Application for a non-material amendment following a grant of planning permission.

Number	27
Suffix	
Property name	
Address line 1	Aldwick Gardens
Address line 2	
Address line 3	
Town/city	Aldwick
Postcode	PO21 3QT
Description of site location must be completed if postcode is not known:	
Easting (x)	491689
Northing (y)	99070
Description

Two storey rear extension	
Reference number:	AW/344/15/HH
Date of decision	05/01/2016

J P Tupper Associates
 20 Sudley Road
 Bognor Regis
 West Sussex
 27 Aldwick Gardens,
 Bognor Regis,
 West Sussex.
Proposed Extension.
 Proposed Ground Floor Plan.
 Scale: 1:50. Drg No.: 7349/01E
 Date: April 2017
 All dimensions to be checked on site.
 Do not scale except for planning purposes

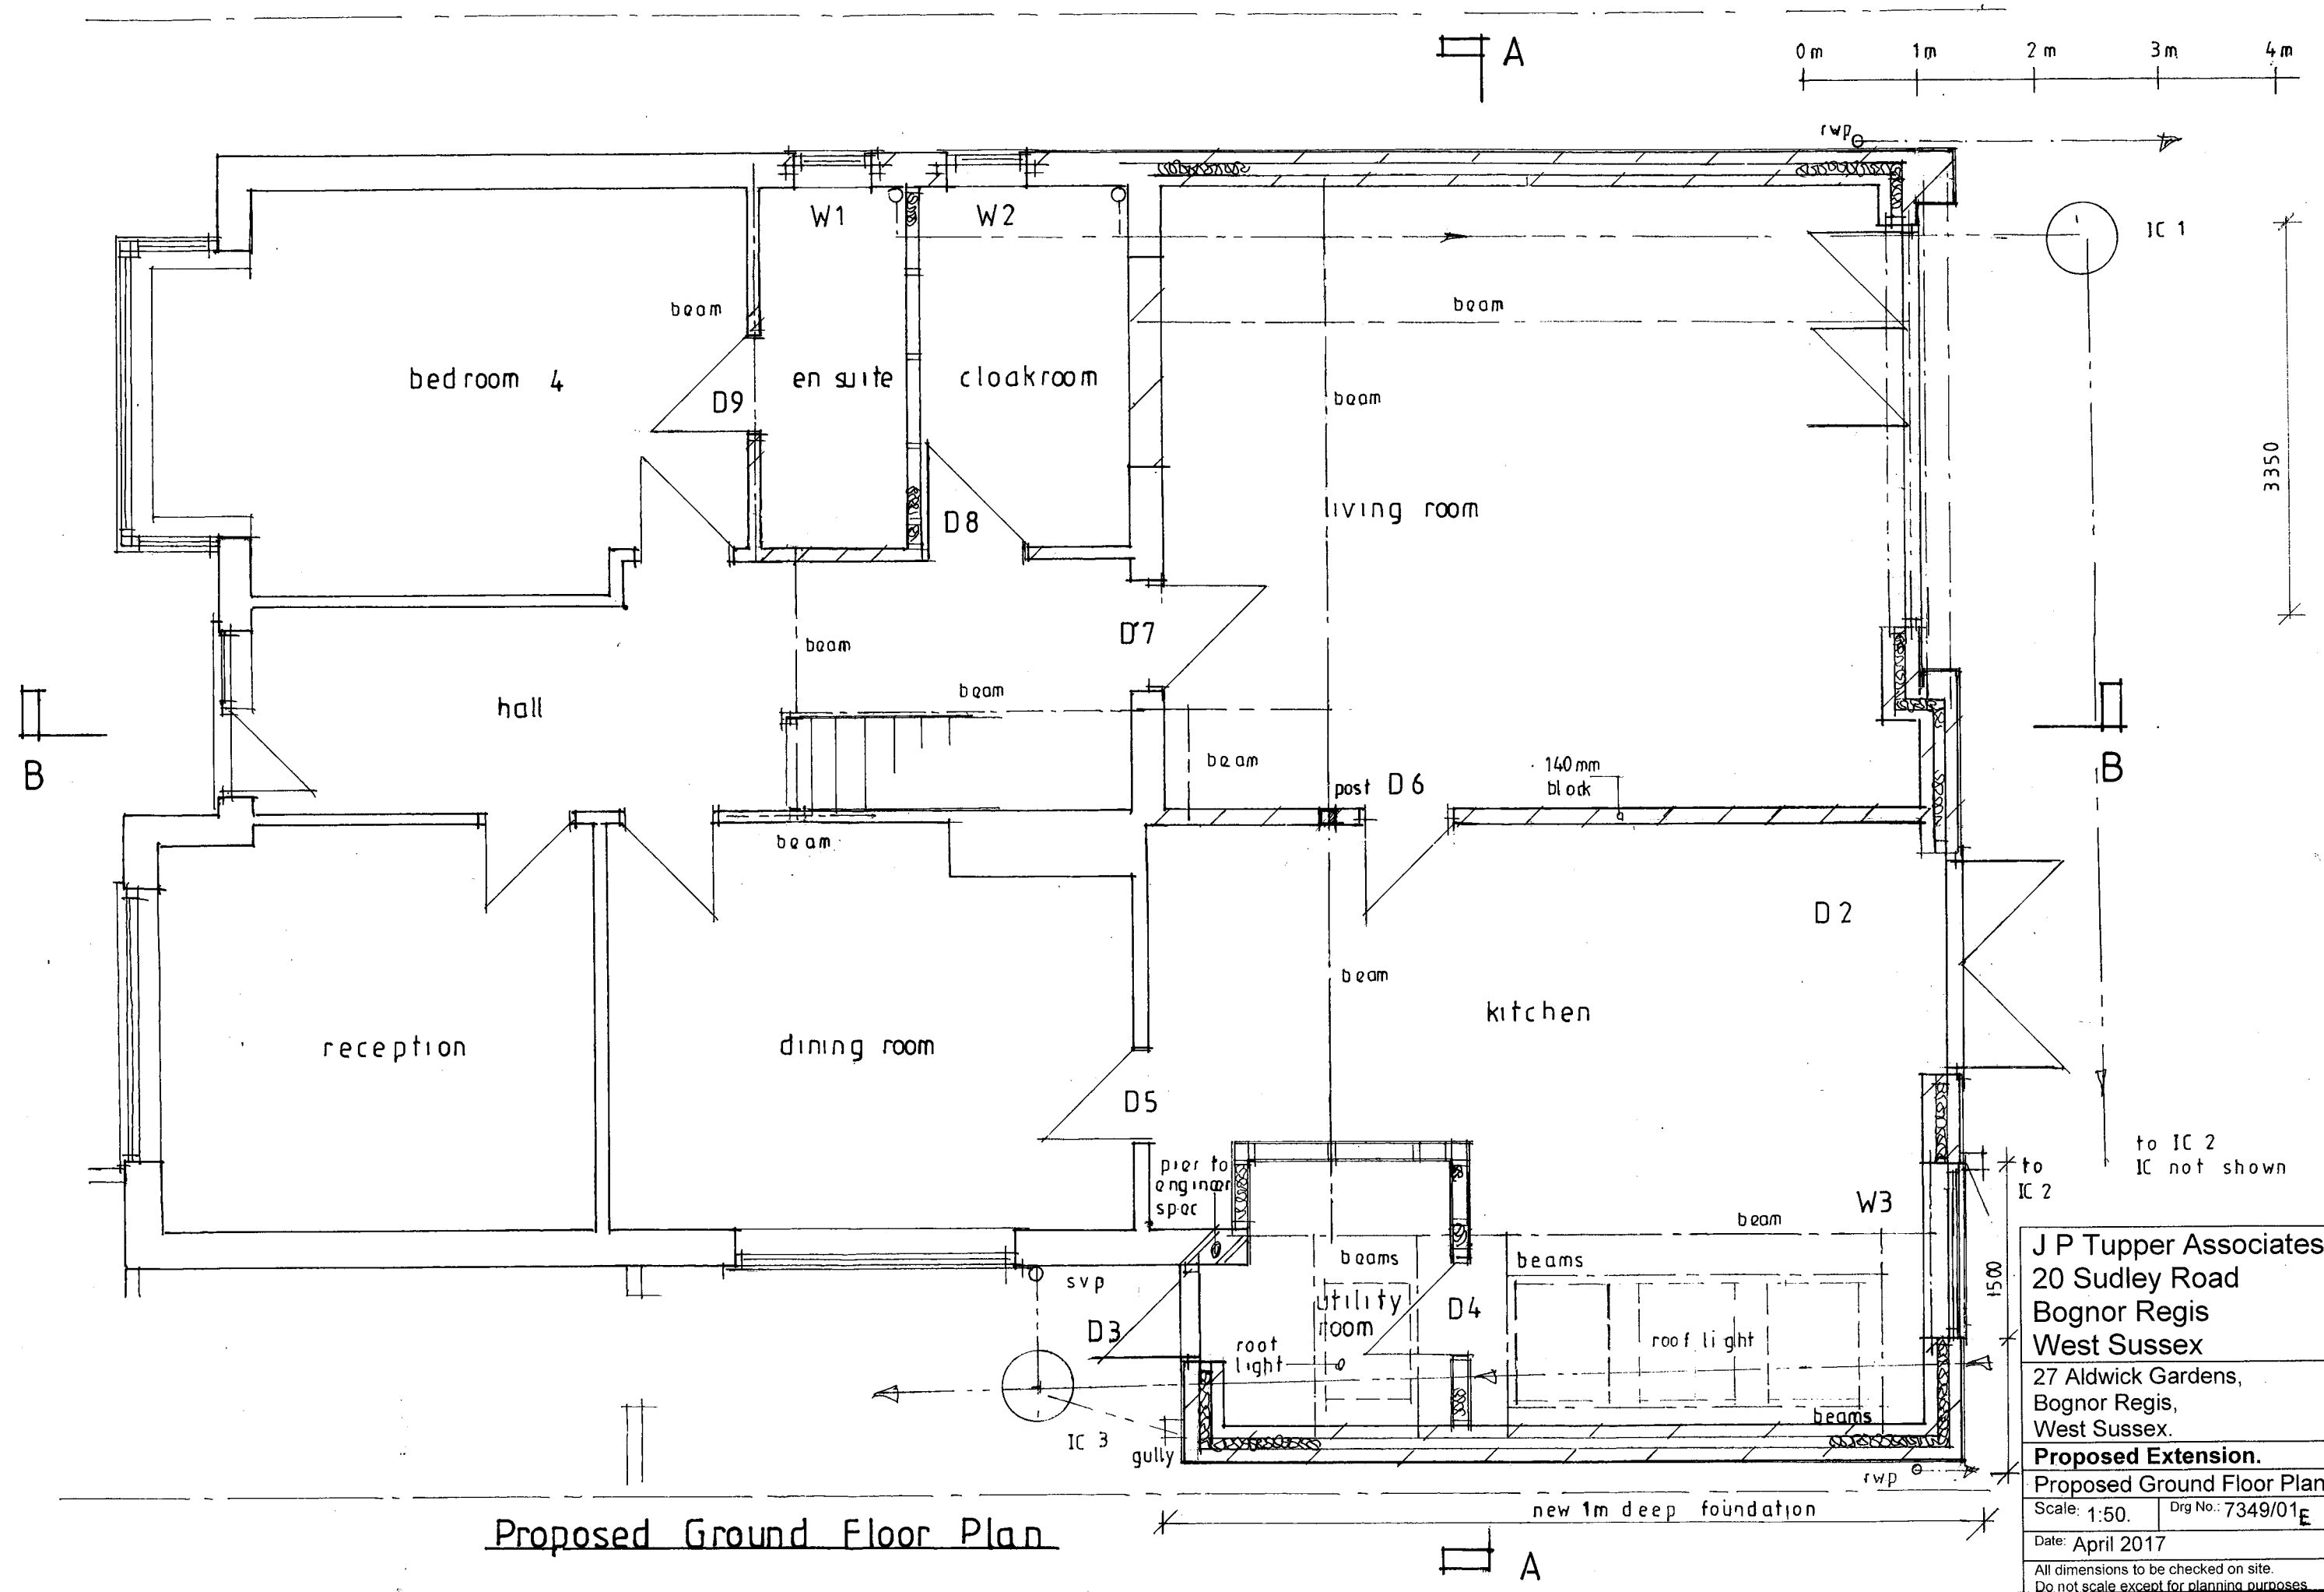
Increase in wall height to west elevation, change in roof pitch to western lower roof slope, reconfiguration of roof lights to western lower roof slope and reconfiguration of south elevation ground floor windows and doors.

Old plan/drawing numbers

7349/01D & 05C

New plan/drawing numbers

7349/01E & 05D
